PLANNING CONSULTATION RESPONSE

Application No	2025/0915
Proposal	Installation of 2no. liquid oxygen storage vessels with vaporisers for medical gas use with associated security and screen fencing and artwork.
Address	Barnsley District General Hospital, Gawber Road, Old Town, Barnsley, S75 2EP
Date of Consultation Reply	14/01/26
Consultee	Nik King, Senior Urban Design Officer

Here are the design comments on planning application 2025/0915.

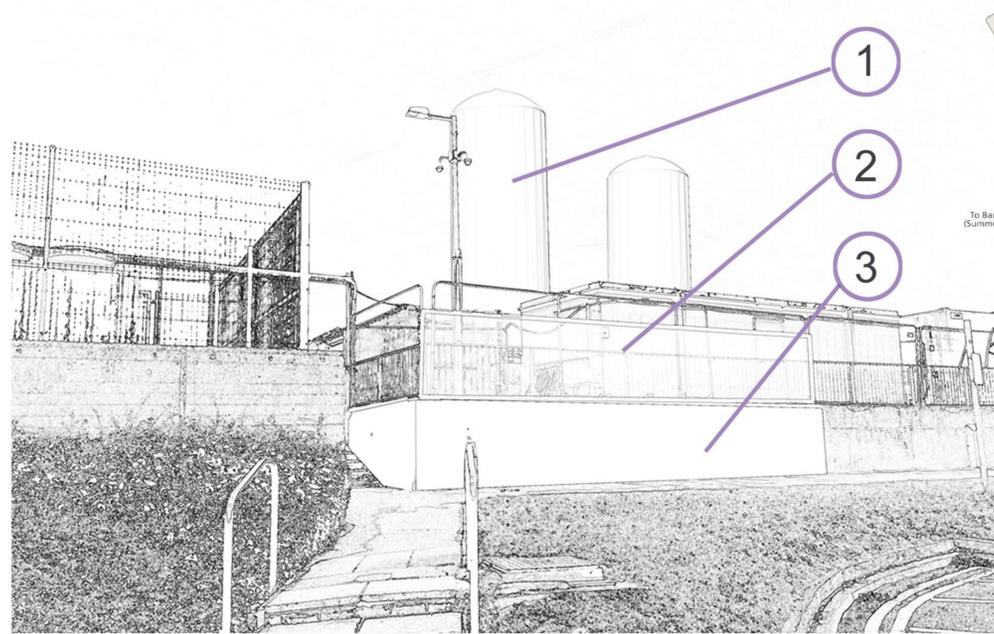
I am supportive of the three artworks. I think the light visual touch of the flower motif on the storage cylinders will help to visually reduce the massing and scale of these structures and make them a distinctive wayfinding element.

Please can the elevation and 3D views be as accurate as possible in the way they show the colours and setting of the artworks

- The flower motifs on the two large cylinders look like computer image 'wraps' on the elevations, but I understand from the explanatory text that they will be painted. Will they end up looking like these images?
- Will the colour of the corten steel darken over time? (It is shown as a golden hue on the elevations).
- It would be good to know if any groups have been consulted about the artwork or have been involved in its design, beyond the management of the hospital. This could help provide extra supporting information in the development management case officer's report.

AXONOMETRIC 3D VIEW 1:100_

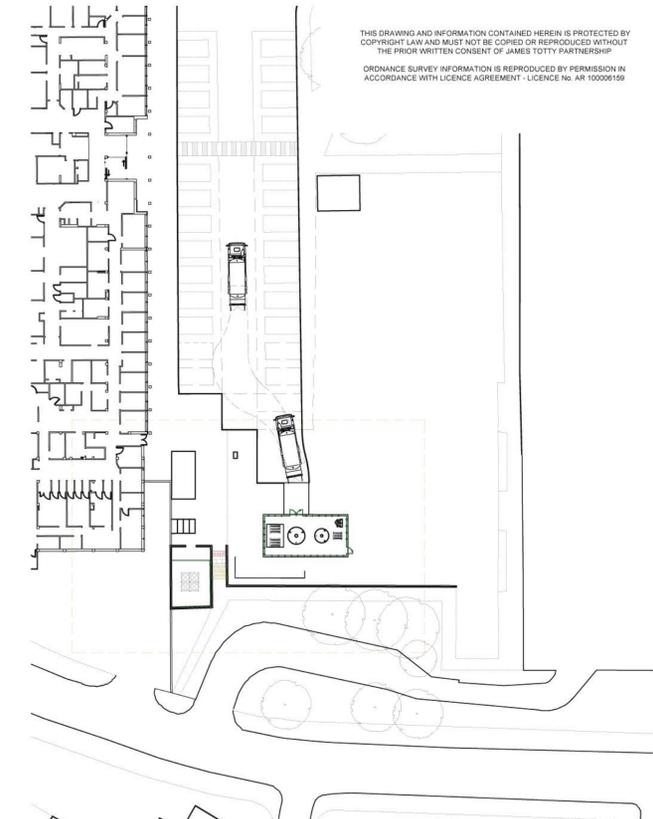
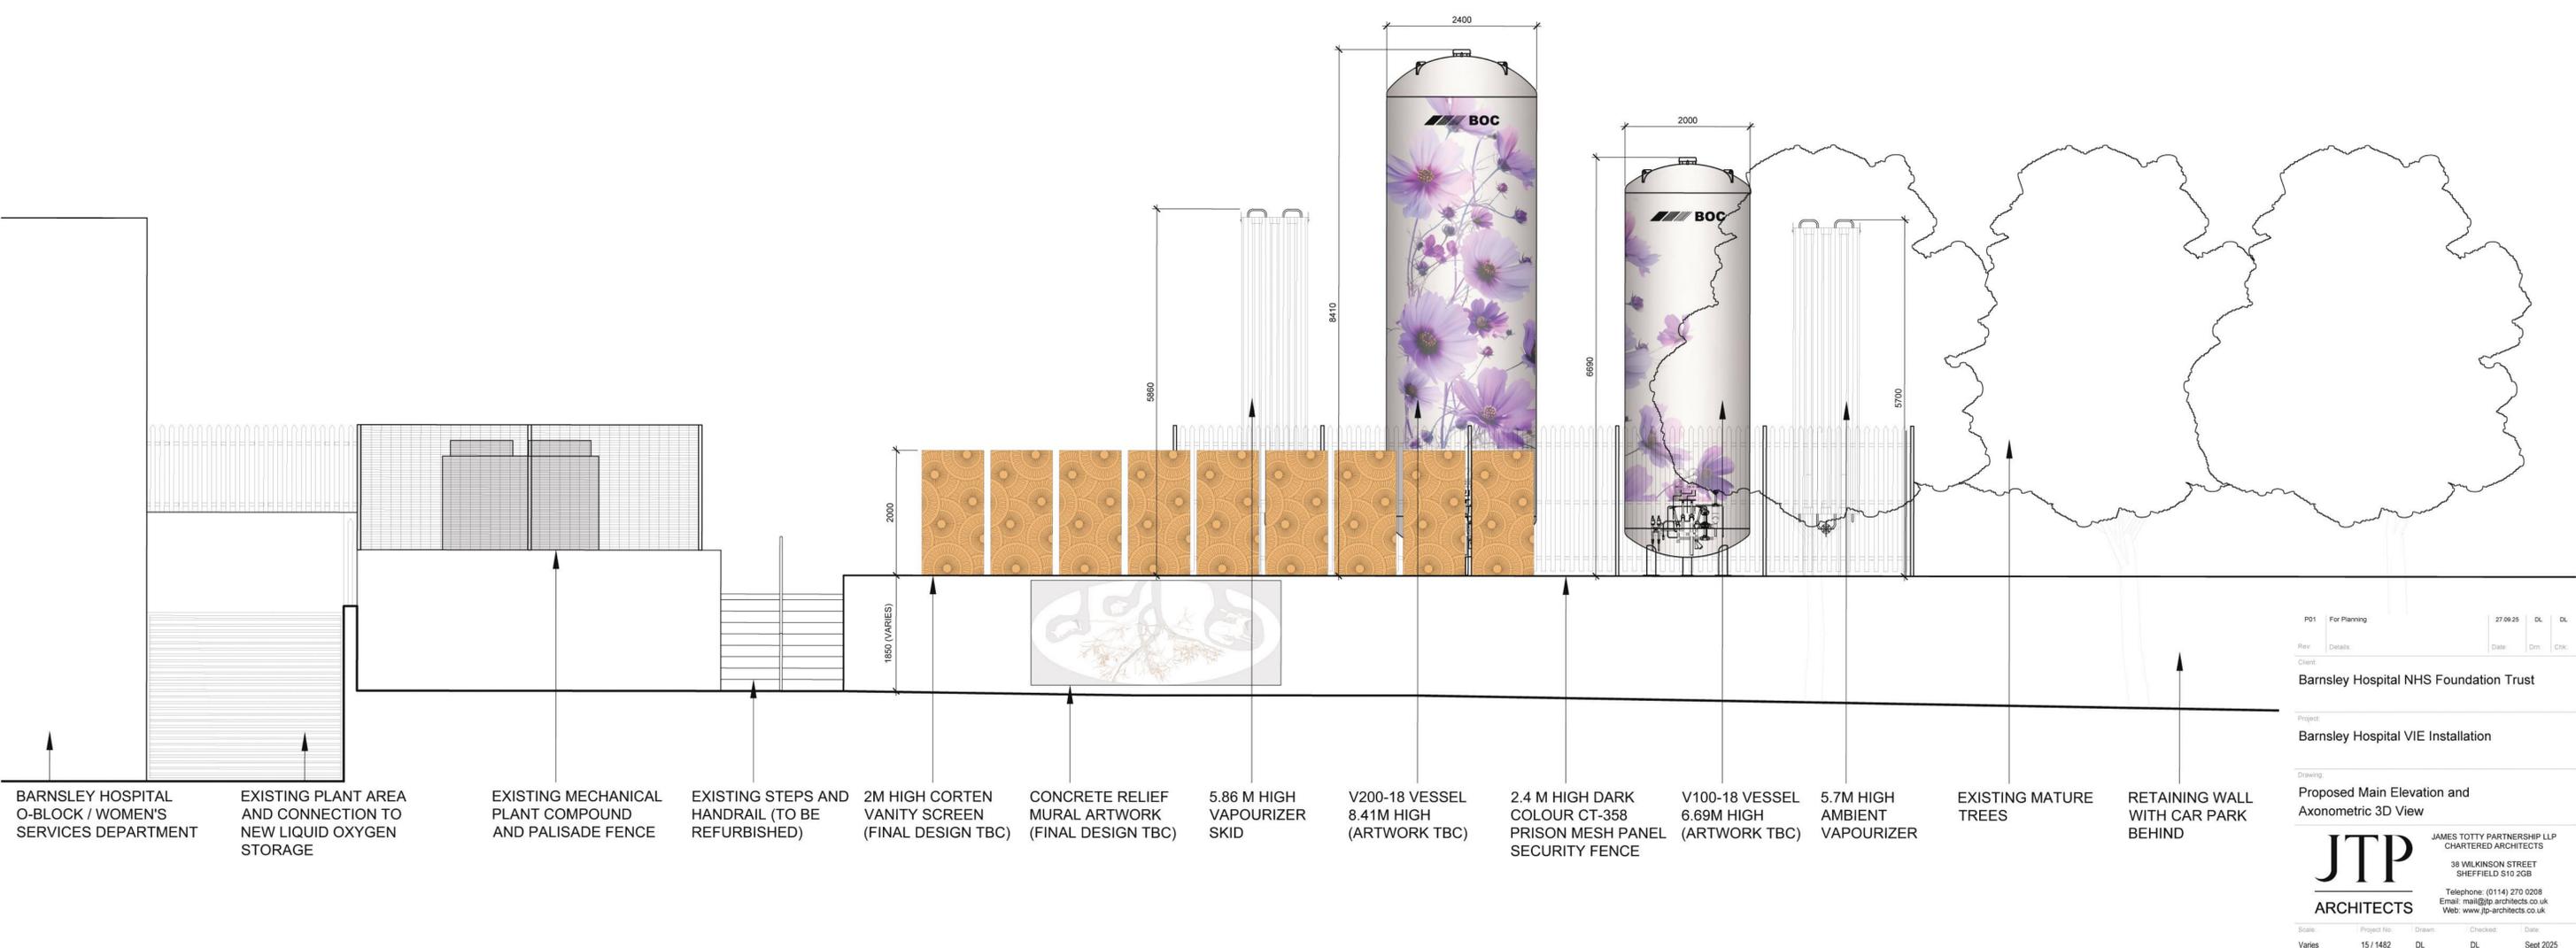
My main concern is ensuring that the proposed 2.4m high corten steel screen does not look imposing on the adjacent pedestrian routes, especially for pedestrians going up the adjacent stairway. The existing pedestrian route towards and up the stairway is currently not a very attractive environment, and I am keen that pedestrians feel safe when walking along this route.

The 3D image shows morning sunlight on the corten fence, but this side will be in shade later in the day and darkness descends about 4pm in the current winter season.

I think a combination of a high degree of perforation of the corten steel and some additional lighting from the existing lighting columns to specifically illuminate both sides of the corten steel at night would help make it appear less imposing and help to allay fears, for example, that someone was waiting and hiding behind the screen, or that anti-social behaviour was occurring behind the screen. Similarly, I would suggest that the CCTV coverage ensures that with the area behind the screen there are no blind spots.

- I am assuming that the existing handrail along the top of the concrete retaining wall will remain (for health and safety reasons to prevent a fall) so this would be in front of views of the corten steel screen. Can this be clarified on the images of the screen and the proposed plan of the site.
- Will the large information board attached to the concrete retaining wall by the steps be staying? (It promotes a smoke free zone). Can this be clarified on the images of the wider setting of the artworks.
- What colour will the vertical pipes (the vaporisers) be? They are just shown faded out in the elevations.
- Will there be any cleaning of the concrete retaining walls, or will they be left as they are?
- Please can the prison grade fencing be in dark green, to match the adjacent fencing, (not black or grey).
